Re: McDonald's - 301 Eubank Blvd SE
Erosion and Sediment Control Plan – L20E004A – (SWQ-2025-00052)
Engineer's Stamp Date: 7/22/25

Based on the information in your submittal received on 11/4/25, the ESC Plan and Notice of Intent (NOI) cannot be approved until the following comments are addressed.

C3.0 SWPPP PLAN

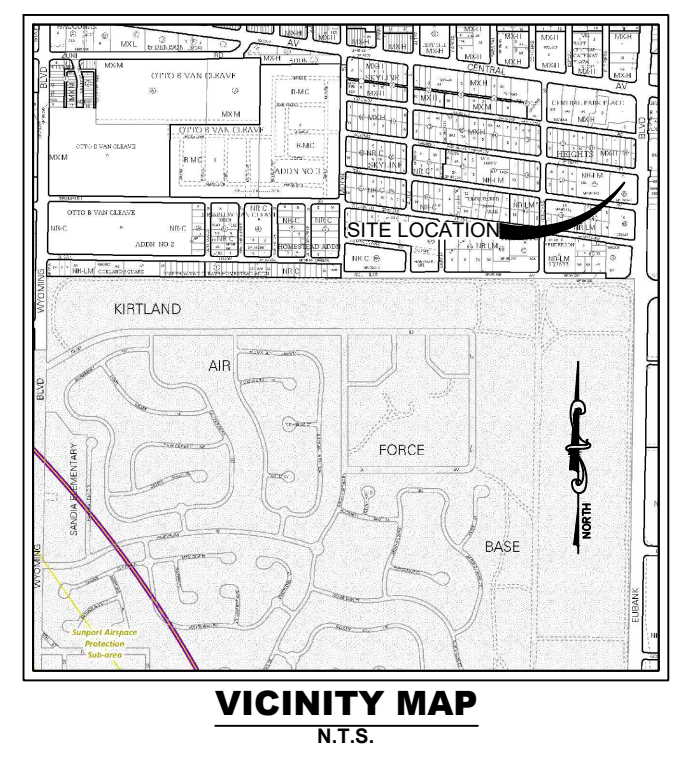
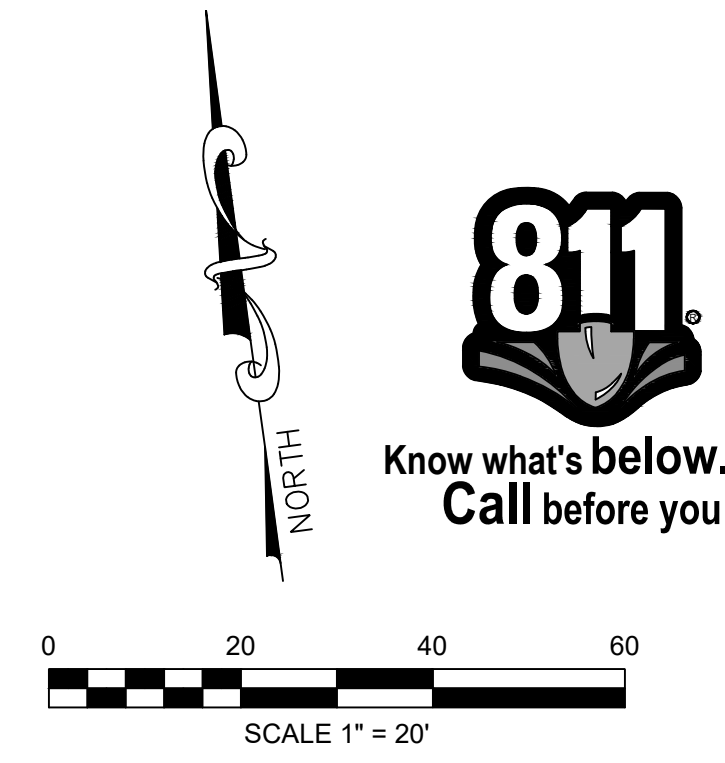
4. It seems likely that the current property owner is responsible for all of the demolition activity on this 1.5-acre tract before McDonald's takes control of their part of this CPODS. The location of the existing buildings and other structures to be demolished must be shown on an ESC Plan per CGP 7.2.4.b.i., whether on the current property owners, Geltmore & Goyim LLC, or McDonald's. Show the limits of demolition for each operator-owner, and identify the anticipated "Conditions for Terminating CGP Coverage" per CGP 8.2 for each owner/operator. Each property owner's ESC Plan and SWPPP must include a sequence/schedule identifying

6. A note on the ESC Plan says, "A SWPPP shall be prepared for McDonald's by others," which implies this isn't McDonald's ESC Plan, and the plan doesn't show the work that will be under the control of the current property owner either. Since each owner is required to prepare a SWPPP before filing an NOI, please include the owner/operator's name(s) on the ESC Plan.

7. The existing and proposed grades are not adequately defined on the ESC Plan to determine drainage patterns as required by CGP 7.2.4.f. The existing and proposed grades must be shown on the ESC Plan and agree with the Grading Plan approved by Hydrology.

8. The SWPPP must include site-specific interim and permanent stabilization per CGP 9.6.1.c.i. The Landscape Plan can be used to satisfy this requirement and should be submitted separate from the ESC Plan with the SWQ resubmittal in ABQ_PLAN and included in the SWPPP. Provide a specification on the ESC Plan for any disturbed areas not covered by the Landscape Plan and specify a "Landscape Buffer Swale" between the sidewalk and curb, per "COA DWG 2414," along Acoma and Eubank Frontage.

9. The frontage improvements along Acoma Rd must be included in the Limits of Disturbance.
10. Update the engineer's stamp date on all sheets whenever a plan changes on any sheet to reflect the engineer's review of the impact across all sheets.
